**KIRKLEES METROPOLITAN COUNCIL
INVESTMENT & REGENERATION SERVICE**

DELEGATED DECISION TO DETERMINE PLANNING APPLICATIONS

Reference No: 2018/62/90807/E

Site Address: 11, Howard Street, Batley, WF17 6AA

front elevation

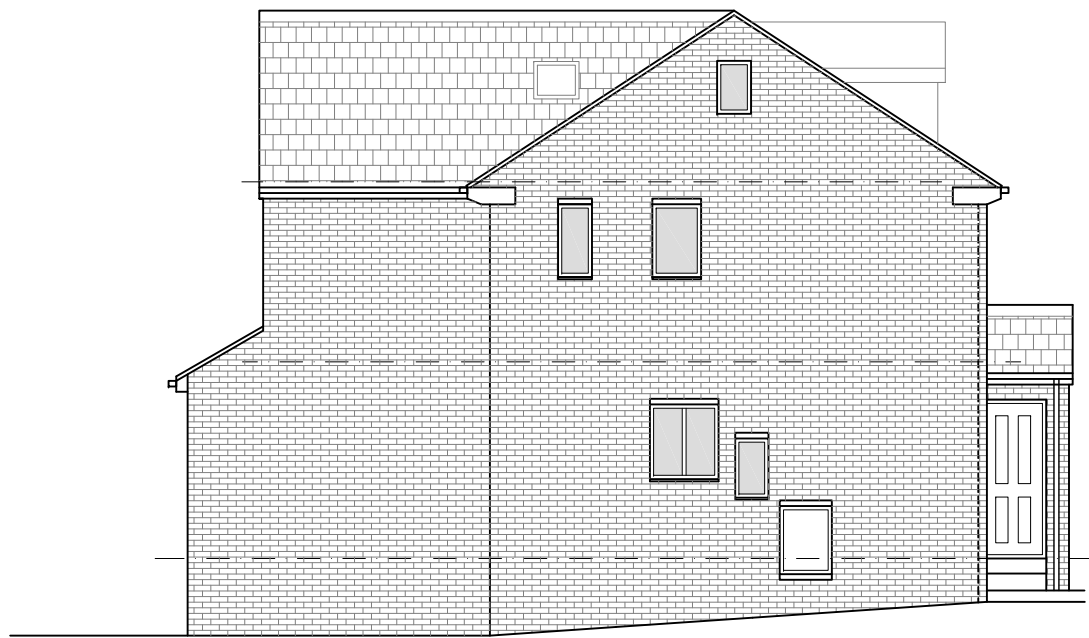
The current application seeks to agree the inclusion of a new first floor window in the front elevation. Whilst the properties within this row have only one window at first floor level, the inclusion of a modestly proportioned window as proposed would not necessarily result in the formation of an incongruous feature. It is considered therefore that the proposed new window would be acceptable in terms of visual amenity.

rear elevation

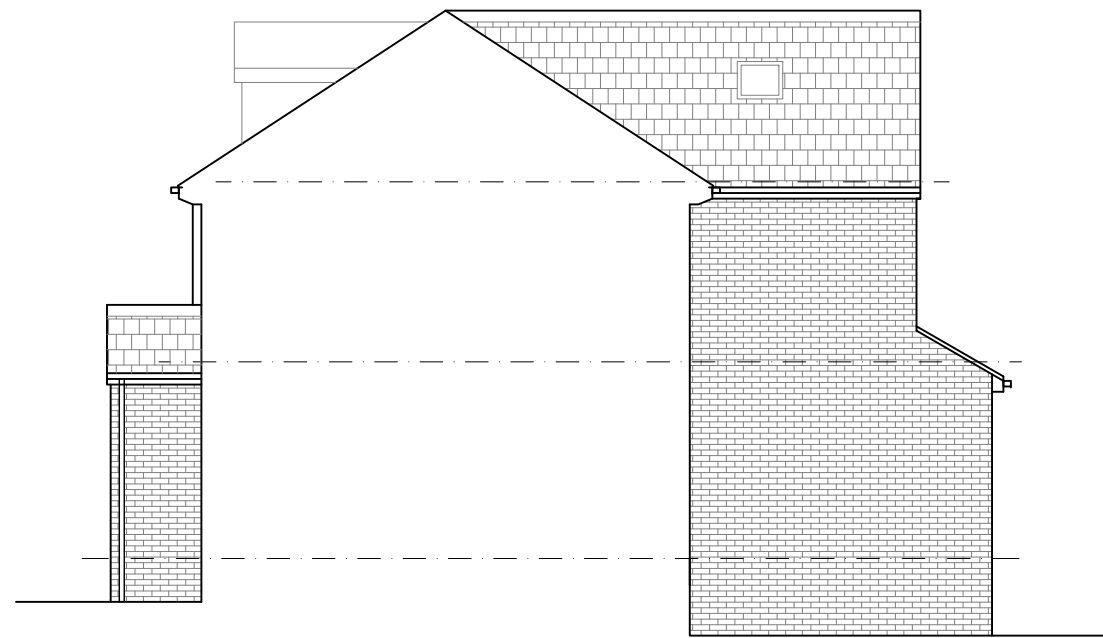
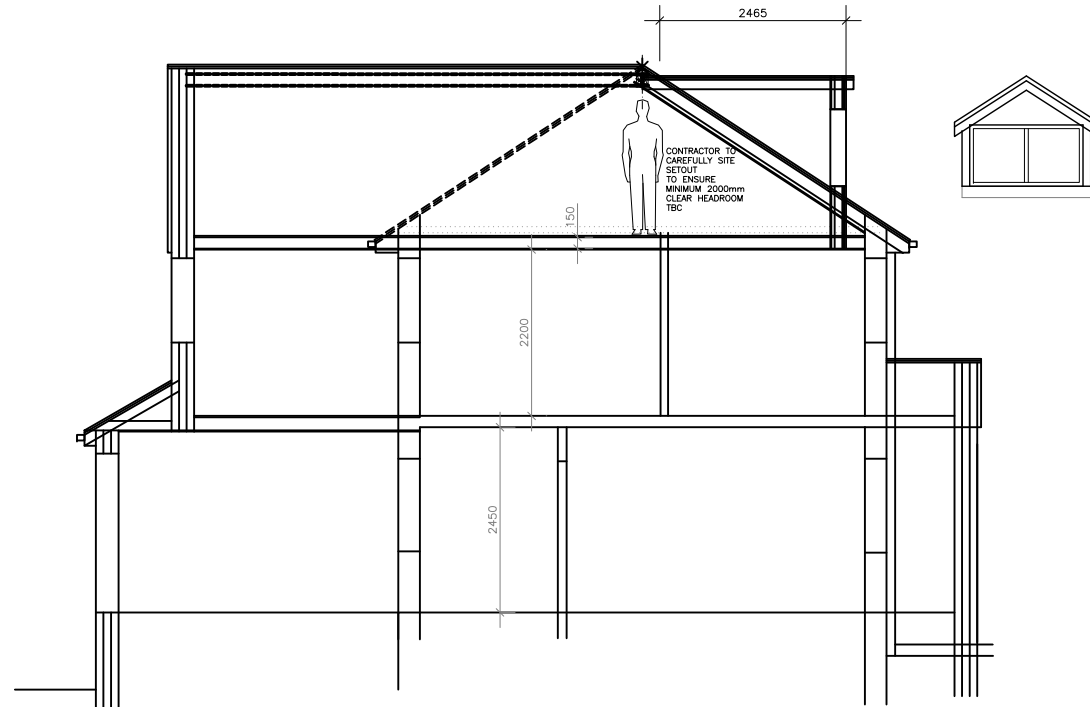
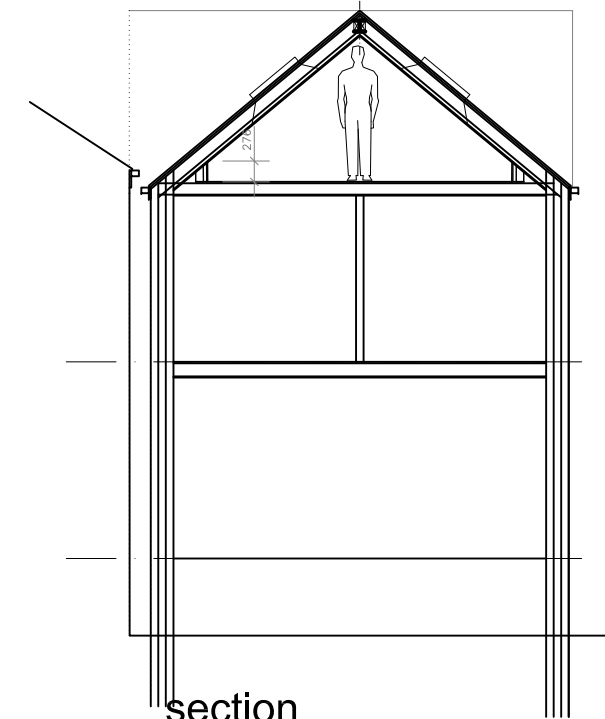
The dwelling has a reasonably sized amenity space to the rear of the dwelling which would support the proposed extension without amounting to overdevelopment. Therefore the size of the first floor would be considered to be acceptable in terms of scale. The projection is limited to 3m which is in line with policy BE14 of the UDP and the materials proposed would utilise brick to match the host property. The detailing proposed would likely result in an appropriate relationship with the host property. As such, this element of the scheme can be considered to be acceptable in terms of visual amenity.
